Agency Review Comments

Rocky Top, Site Development Plan

PPR1913

LDC Comment Responses 08.30.19
 David V. Hostetler - DVH
 dhostetler@ldc-inc.com
 (719) 528-6133

LANDSCAPE PLAN AREA A

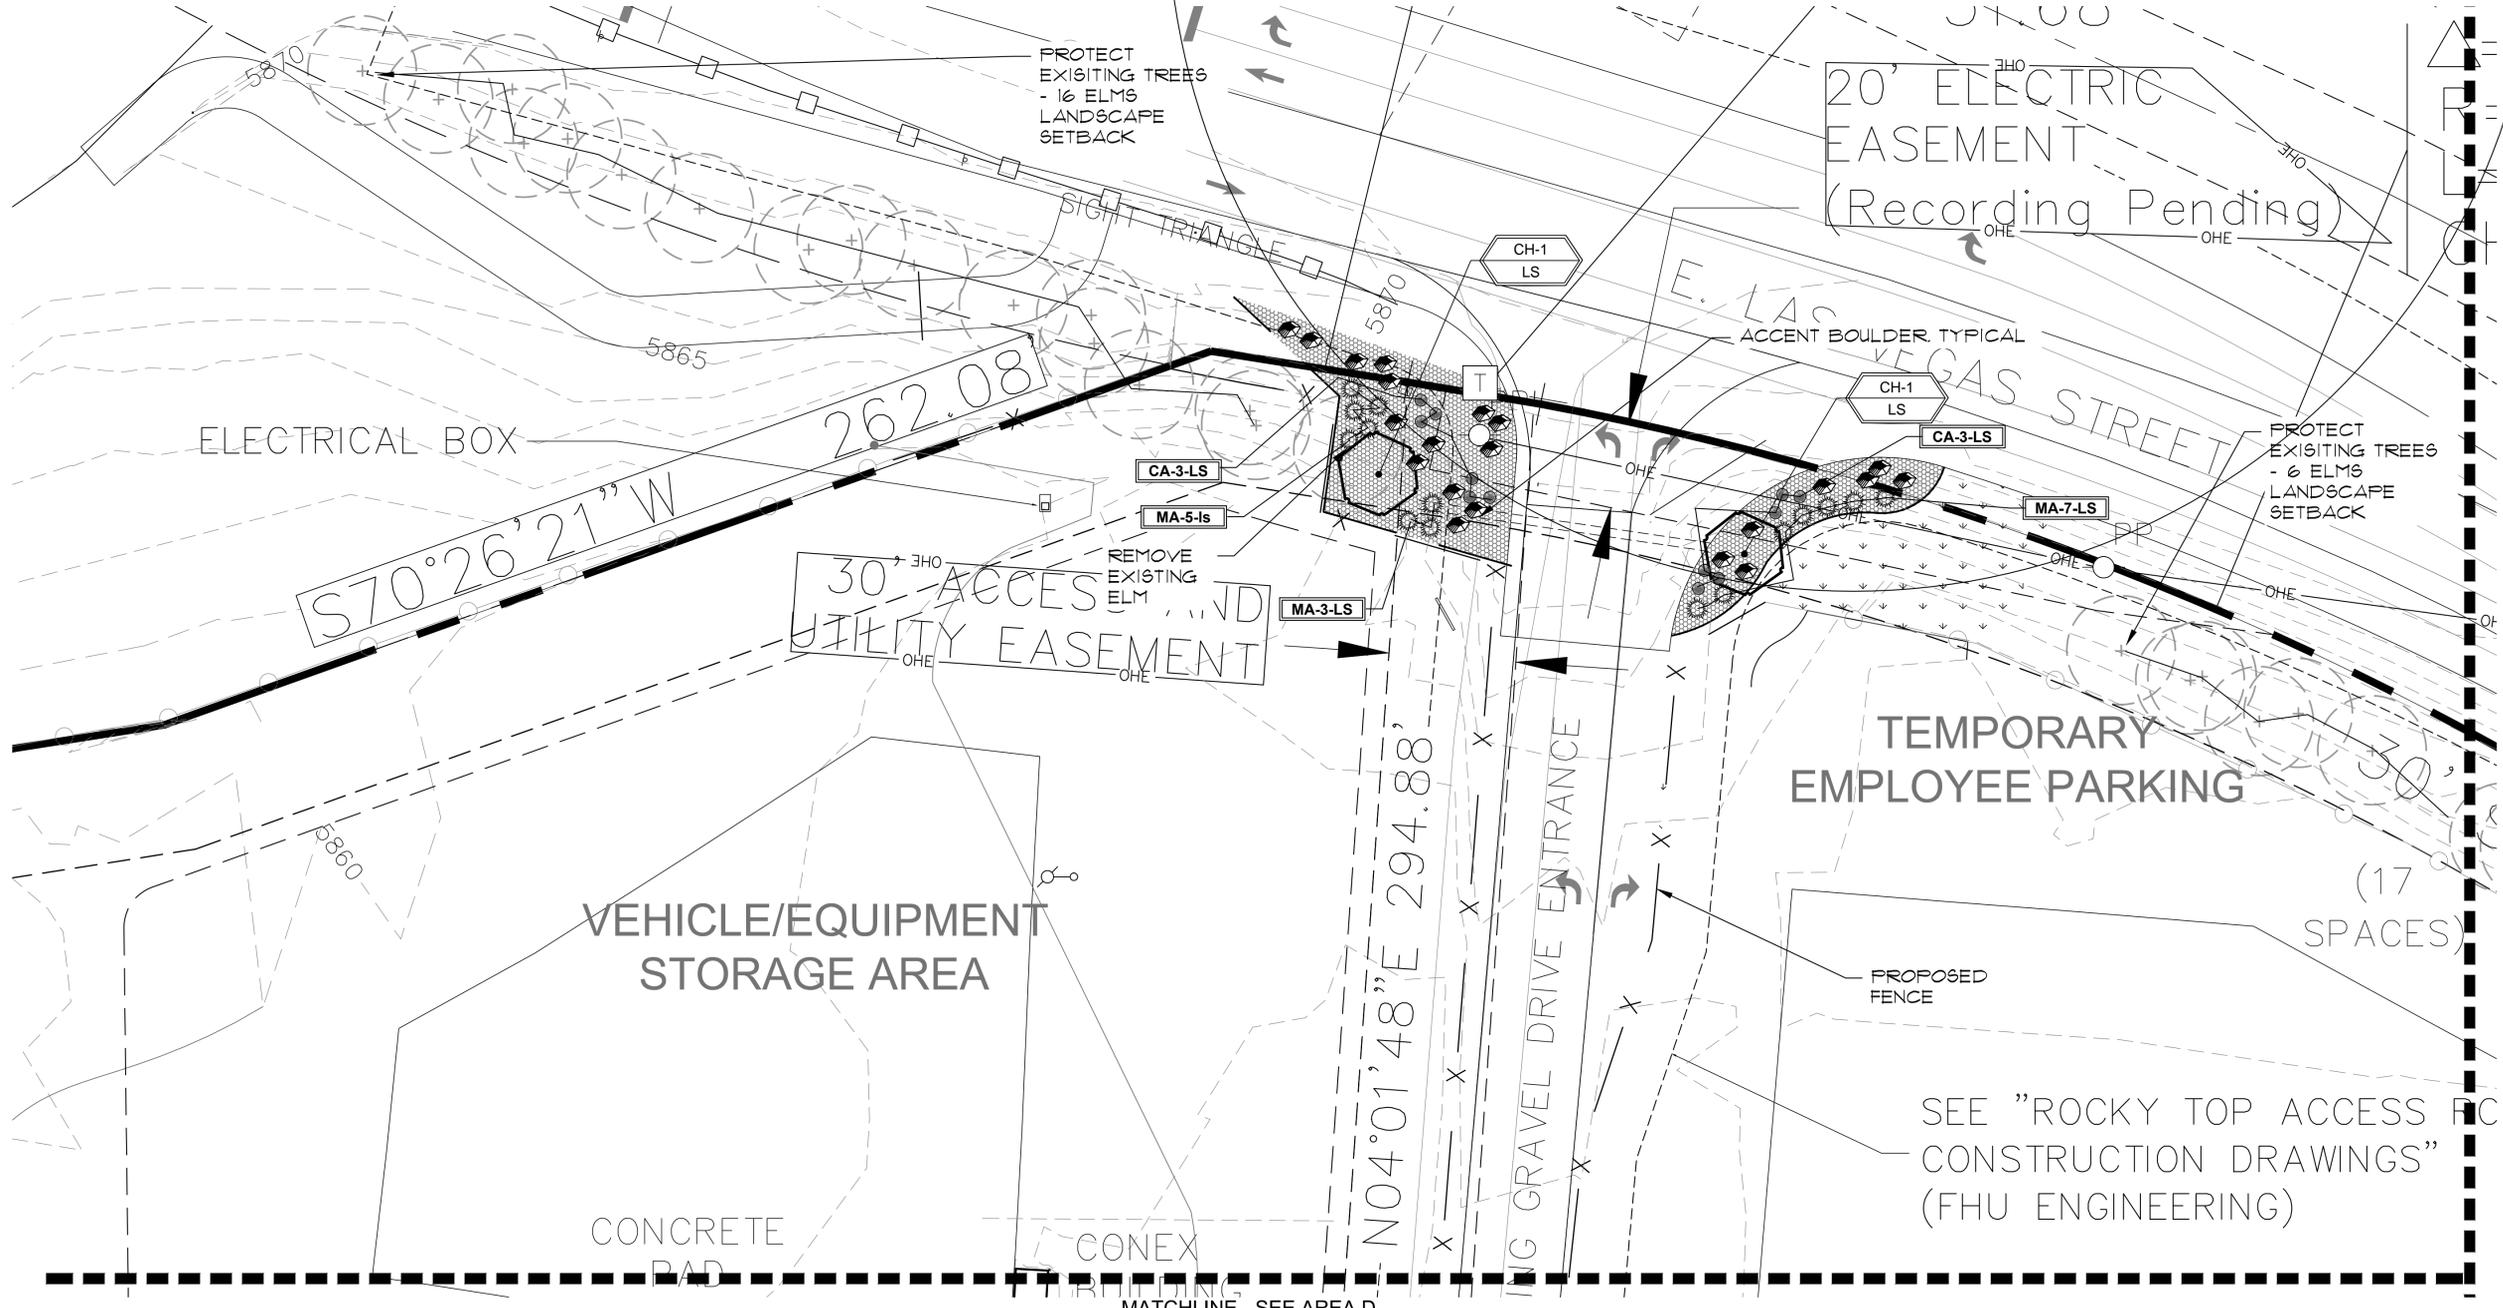
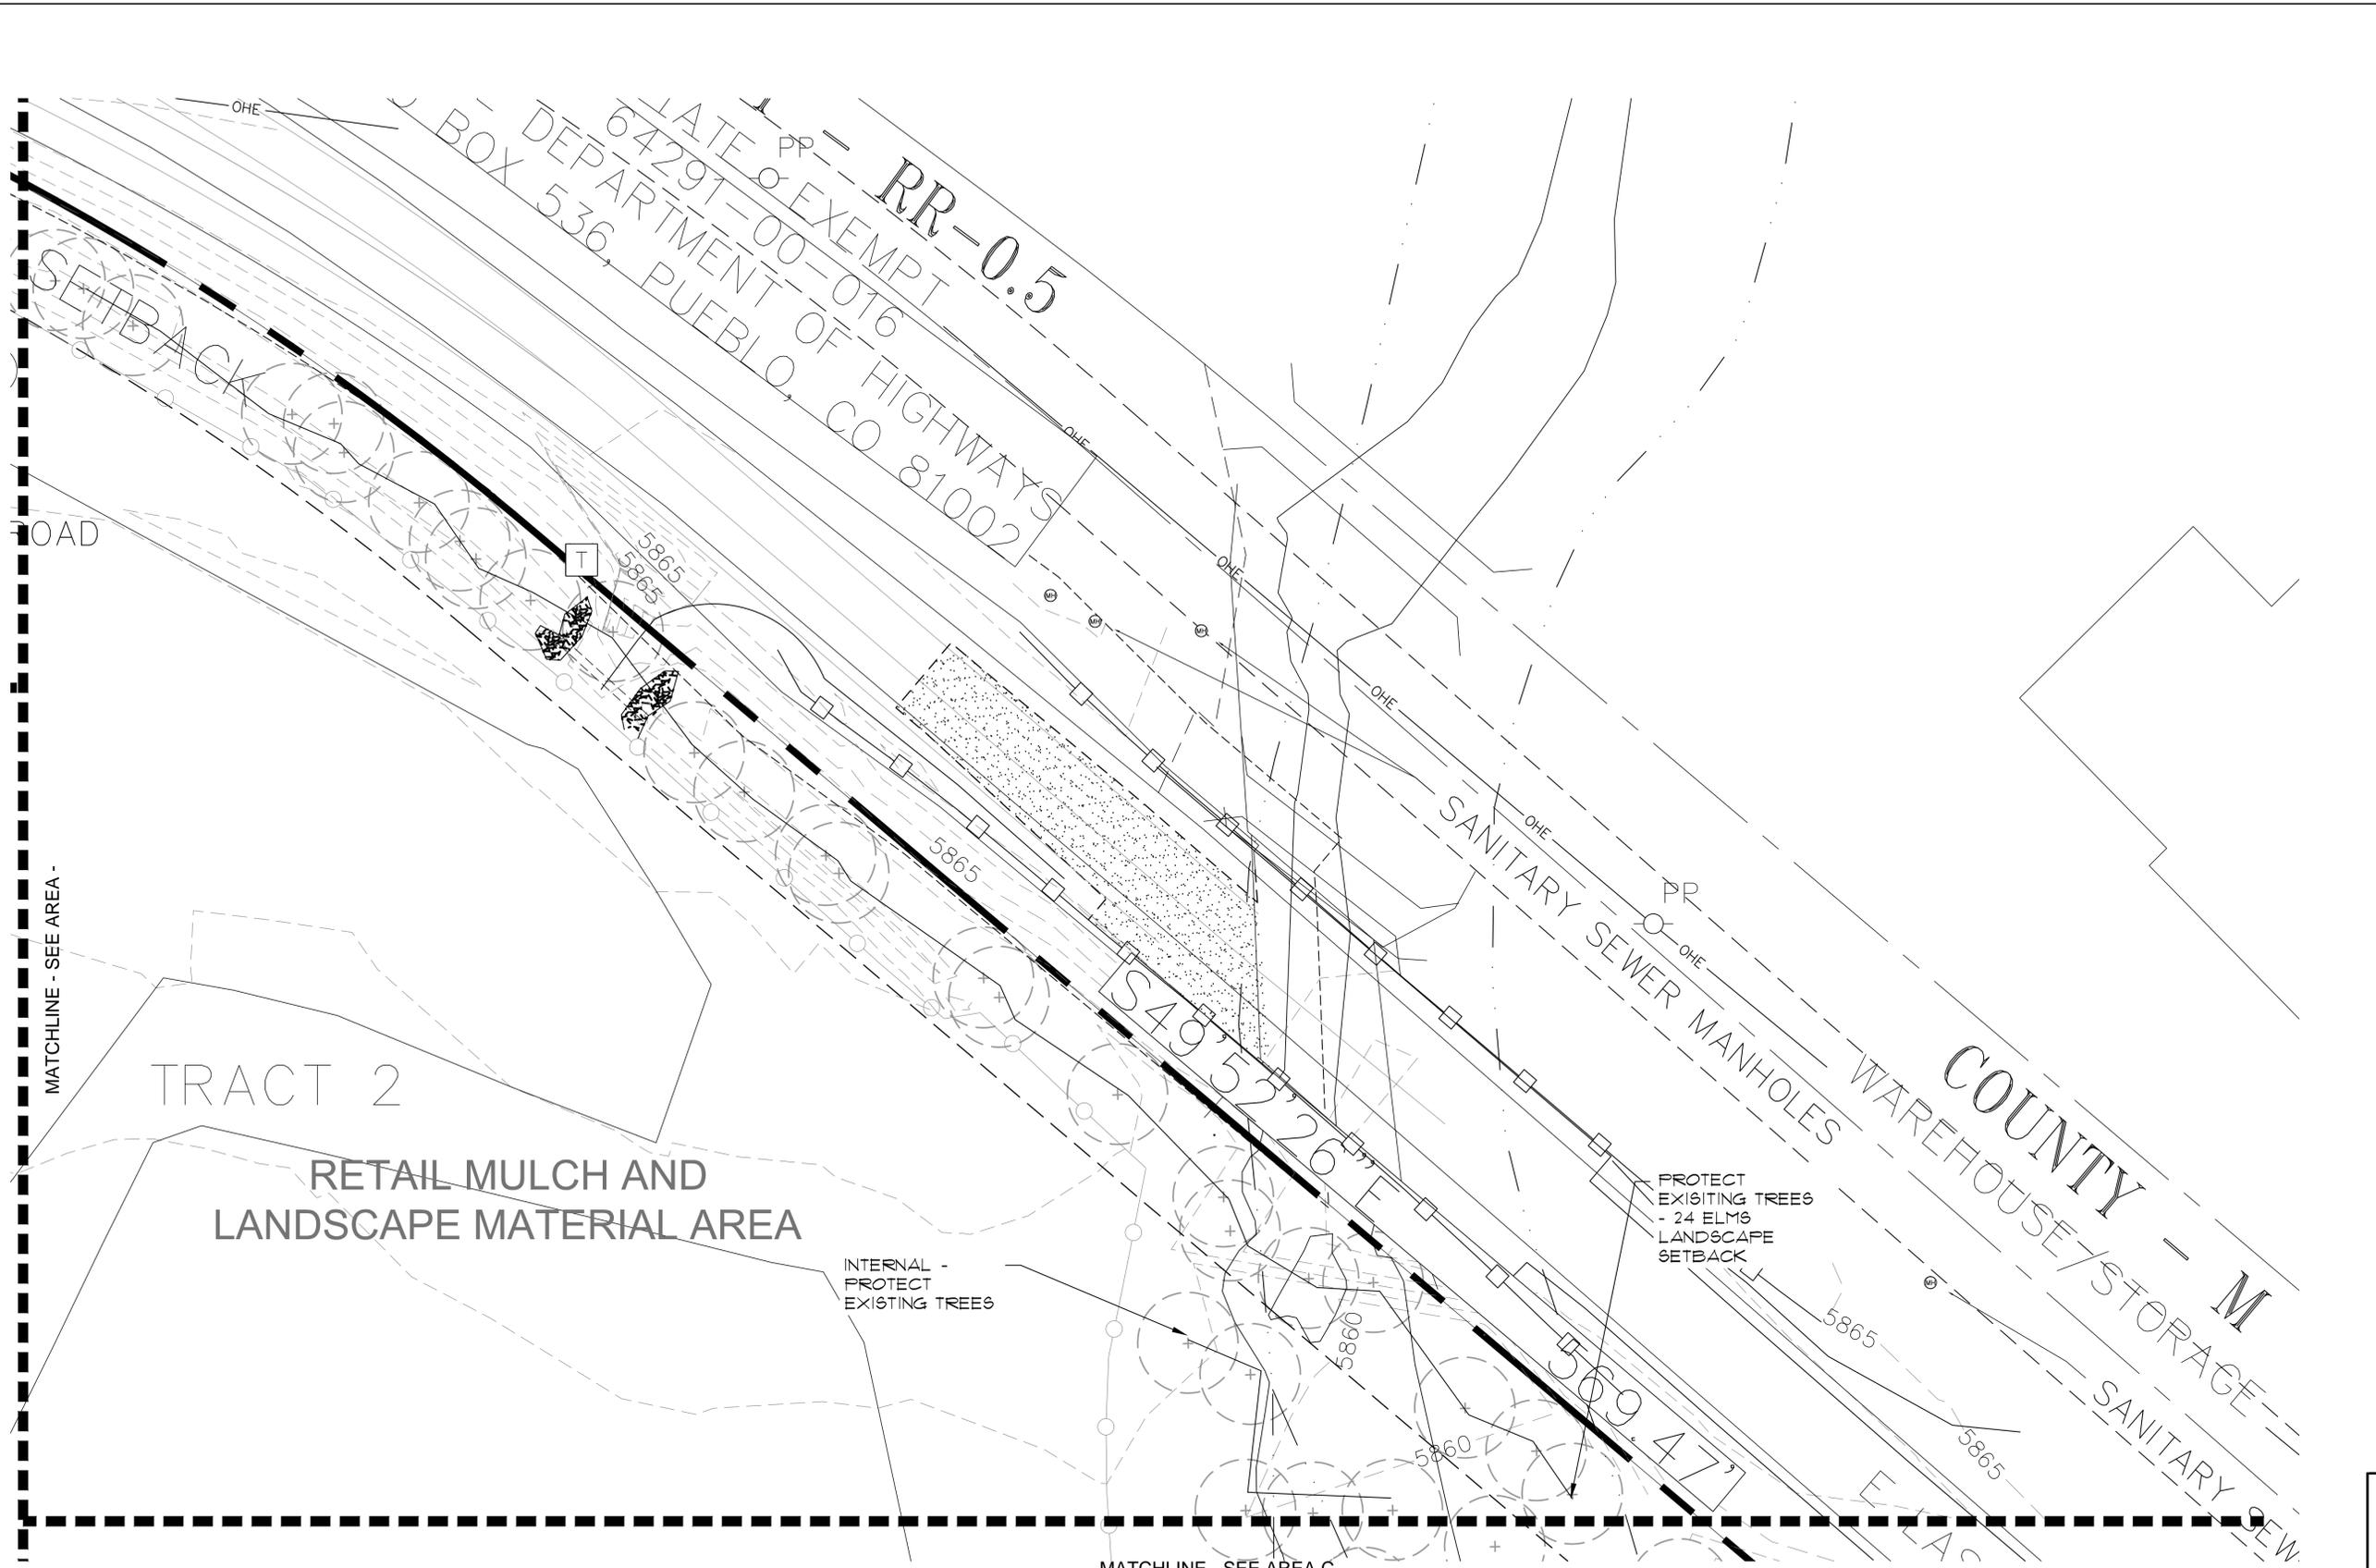
Please indicate that the existing trees are intended to stay.

Landscaping requirements pertain to the whole site. What are the required tree along Las Vegas and how many are being provided? Please provide information in the plant schedule. If the existing trees along Las Vegas are to remain, the plan must reference that information.

Section 6.2.2(C) Parking Lot Landscape Requirements. There are no trees indicated in this parking lot detail.

See revised Landscape Plan - DVH
